Development Facilitation Team (DFT) – Review Comments

Project No: PR-2023-009411 Date: 2/07/2024 Agenda Item: #5 Zone Atlas Page: G-15

Location: [501 CANDELARIA RD NE between 2nd ST NE and HIGH ST NE]

Application For: SD-2024-00018-PRELIMINARY/FINAL PLAT (DHO)

PLAT OF
TRACTS B-1-A-1 & B-1-A-2
SUNDT'S INDUSTRIAL AREA

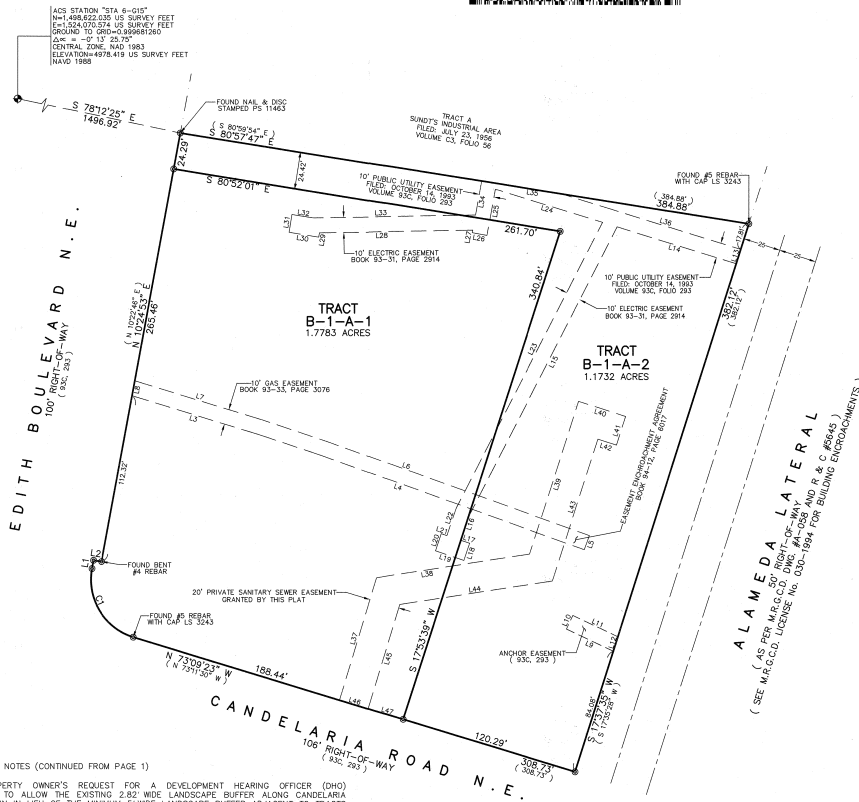
1. Previous Comments: (Accounts have been verified, do easements still need to be incorporated? Is there an exhibit that shows the locations?)
 - a. No objection, however, please confirm the lots have separate water and sanitary sewer services and have adequate easements if the private services are crossing lots. Provide an exhibit showing that is the case.
 - b. For future development, Request an availability/serviceability statement online at the following link: http://www.abcwua.org/Availability_Statements.aspx. Requests shall include fire marshal requirements.

- Add a Cross Lot Drainage Easement note specifying the beneficiary and maintenance agreement.
- Comment – Prior to submitting for Building Permit, a licensed New Mexico civil engineer will need to submit a Grading & Drainage Plan to Hydrology for review & approval if one of these conditions is met. (500 cy of grading, 1,000 sf of proposed building, or 10,000 sf of proposed paving).
